**Re: ESR HORSLEY LOGISTICS PARK  
SSD-10436**

We refer to the above State Significant Development Application relating to construction, fit-out and operation of warehouses and distribution buildings. Our property (Lot 71, DP 1050228) is located on Greenway Place approximately 80 metres from the boundary of the site. Please refer to the aerial photograph included on page 20 of the Environmental Impact Statement, which identifies our property with the Lot/DP noted above.

Drawing Title:
Landscape Detail Plan - Sheet 1
 DWG No:
LDA-02

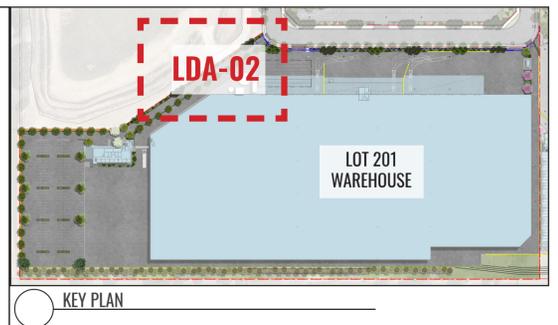
The Landscaping Plans prepared by Geoscape (ESR's Attachment D to the EIS), indicate that the landscaping on the southern boundary has been completed 'by others', i.e. CSR. However, the number of trees that have been planted is inadequate, particularly in the area over the gabion wall. ESR's documents indicate that the visual impact on the rural residents on Greenway Place is 'moderate' but will be mitigated when growth of the plants is completed in 15 years' time. We disagree that this is an acceptable outcome. Firstly, we previously enjoyed beautiful rural and Blue Mountains views, which are now being replaced by warehouses 15 metres high. Secondly, 15 years is a long time to wait for an acceptable visual outlook. There needs to be more established trees planted within a short time frame. With the small number of trees that have been planted, it is impossible for the outlook to improve, even within 15 years. There is only a single row of trees, which have been spaced quite far apart. There needs to be at least another row of trees behind them.

In order to ensure the landscaping does meet its objectives, there needs to be a Vegetation Management Plan that includes that southern boundary facing the residents on Greenway Place. The landscape management plans included with the application exclude this area, as they indicate that it is managed by others. This area needs to be maintained to ensure adequate growth and establishment over an extended period (normally 5 years from planting), to ensure the trees and shrubs survive for the long term. Over extended dry periods (e.g. last Summer), all the vegetation will need to be watered to ensure survival. Once CSR settles on sale of the land to ESR, we are concerned about who will be looking after this landscaping, to ensure it delivers the desired outcomes.
